Appendix A – Response to Submissions

Extracts from public authority submissions and submissions from organisations, including stakeholder and interest groups, received in relation to SSD-10416 and a response to each of these matters has been provided in the sections below.

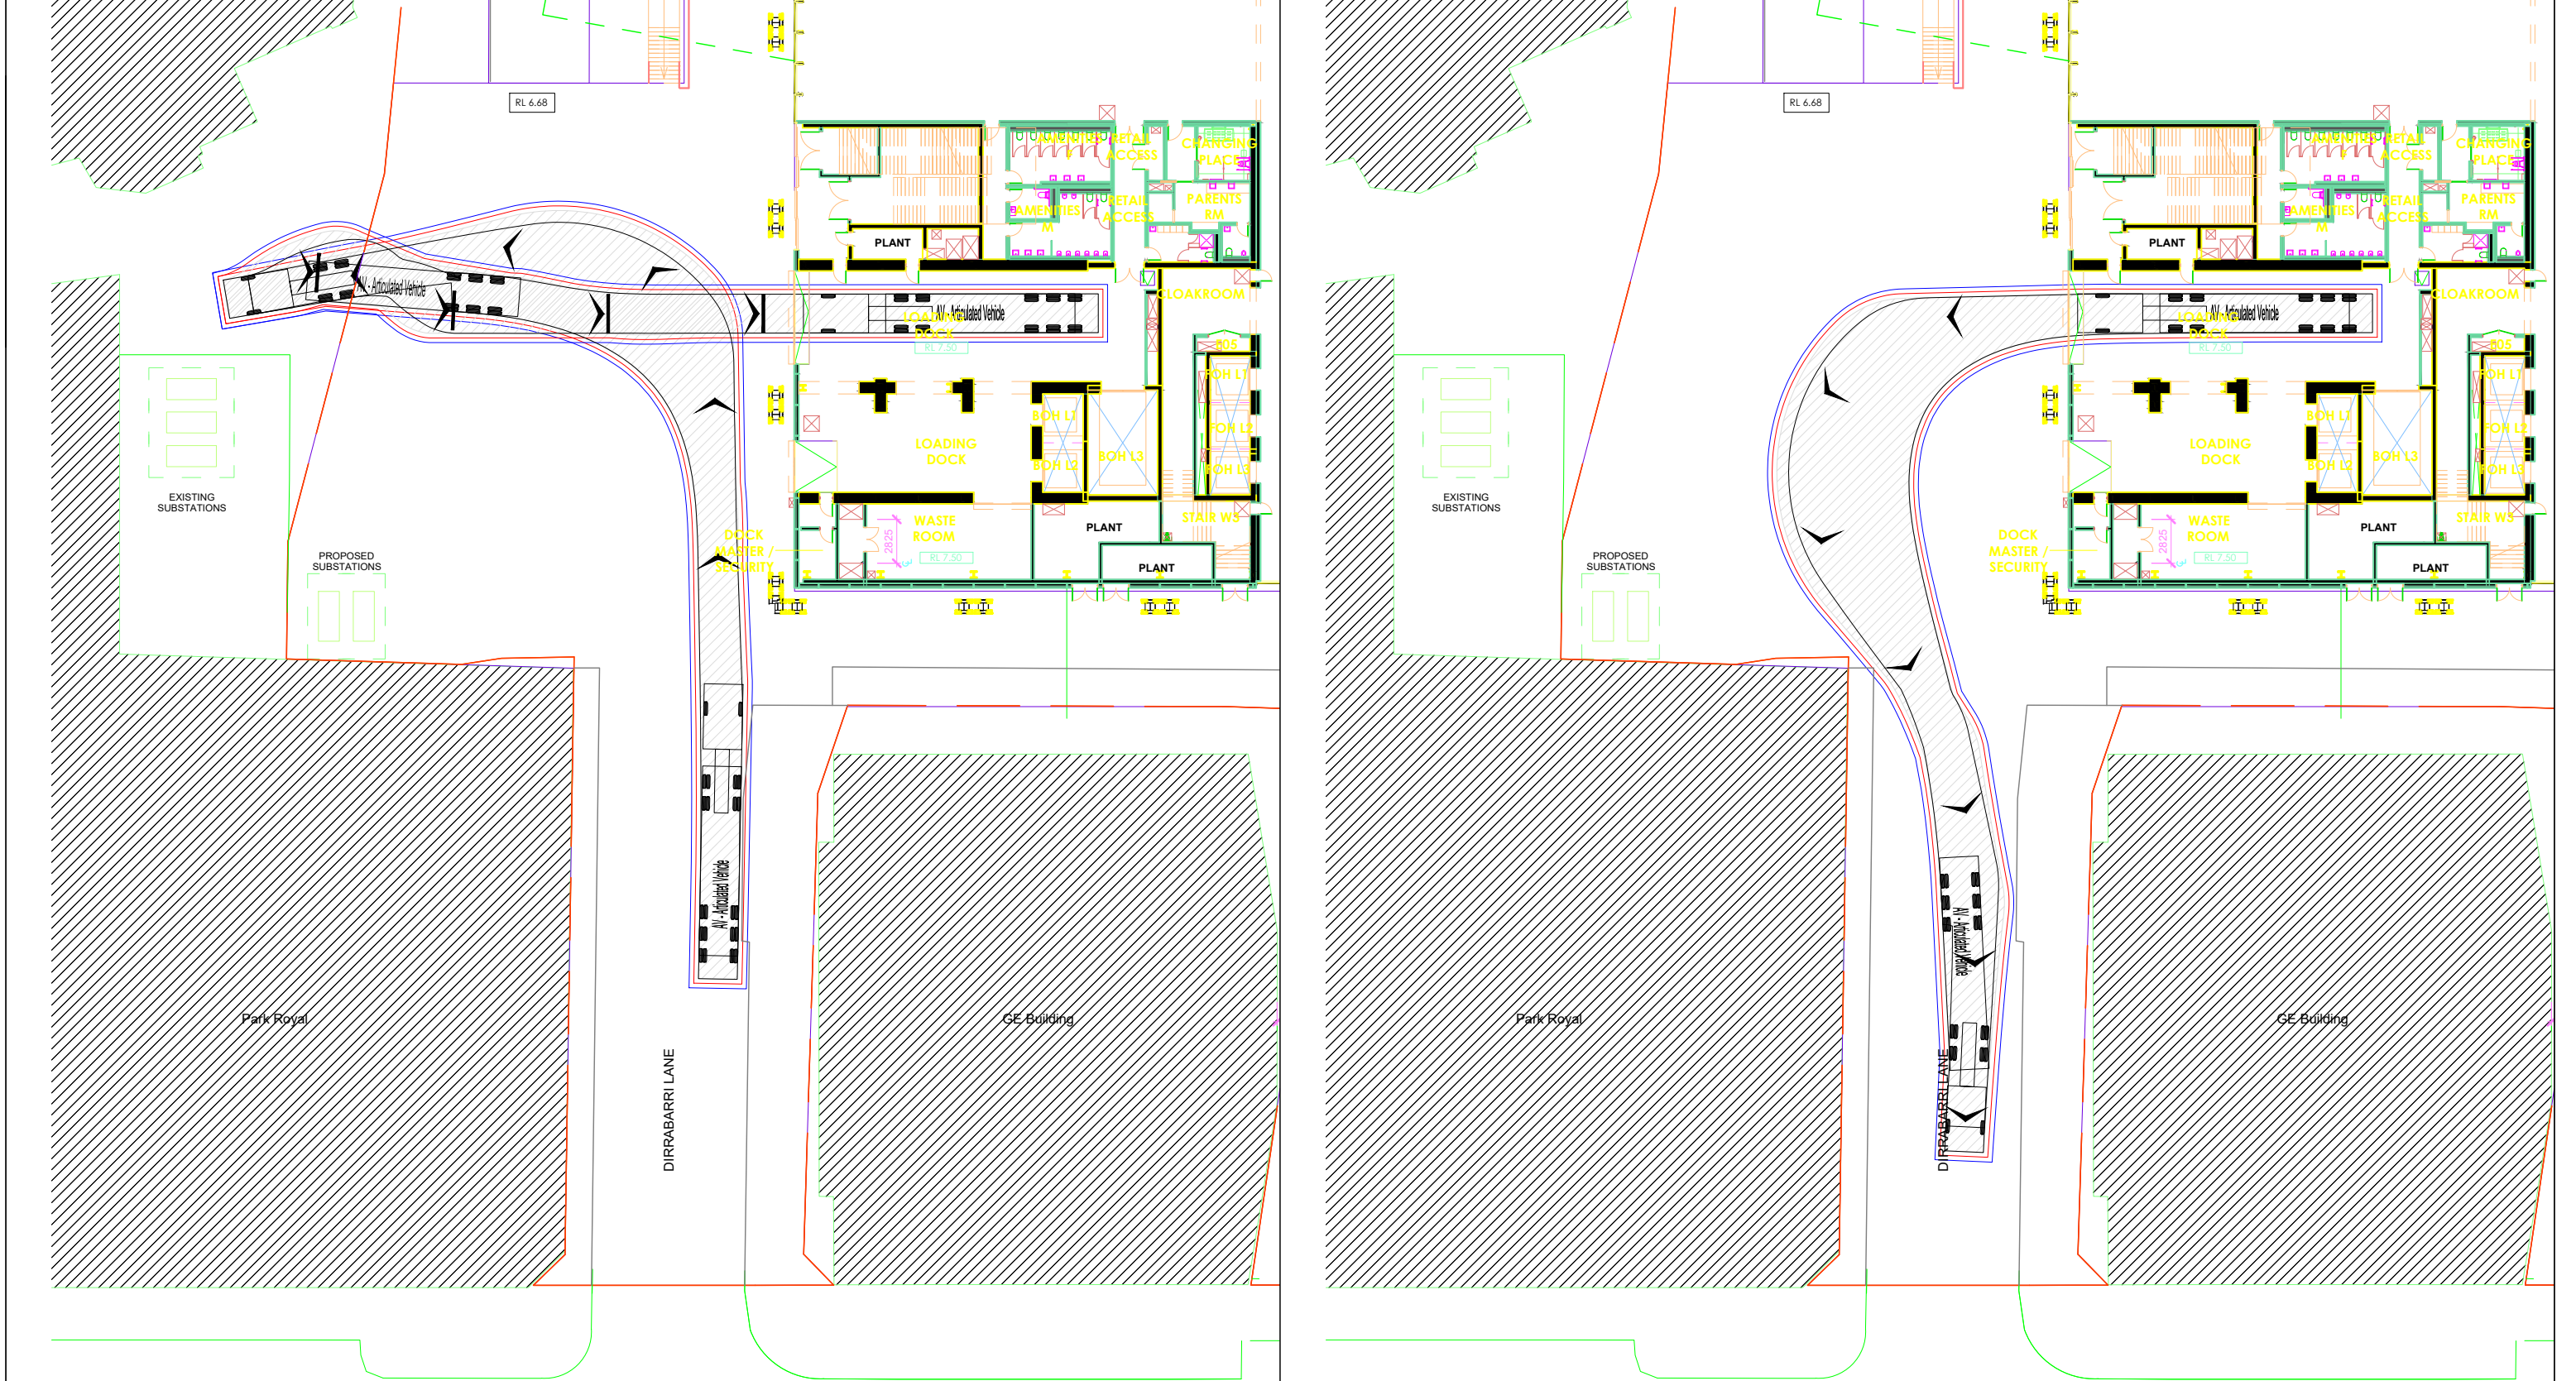
TfNSW10	<p>Other Issues <u>Comment</u> The following issues are identified in the Transport Impact Assessment:</p> <ul style="list-style-type: none"> • Section 2.2: Content under this section should make reference to Future Transport 2056 as appropriate. • Section 3.2.2: Update to state that bus lane on Smith Street and Wilde Avenue were completed in April 2020. 	<p>JMT Consulting has prepared an updated Transport Assessment, provided at Appendix K of the RTS Report, addressing these matters.</p>
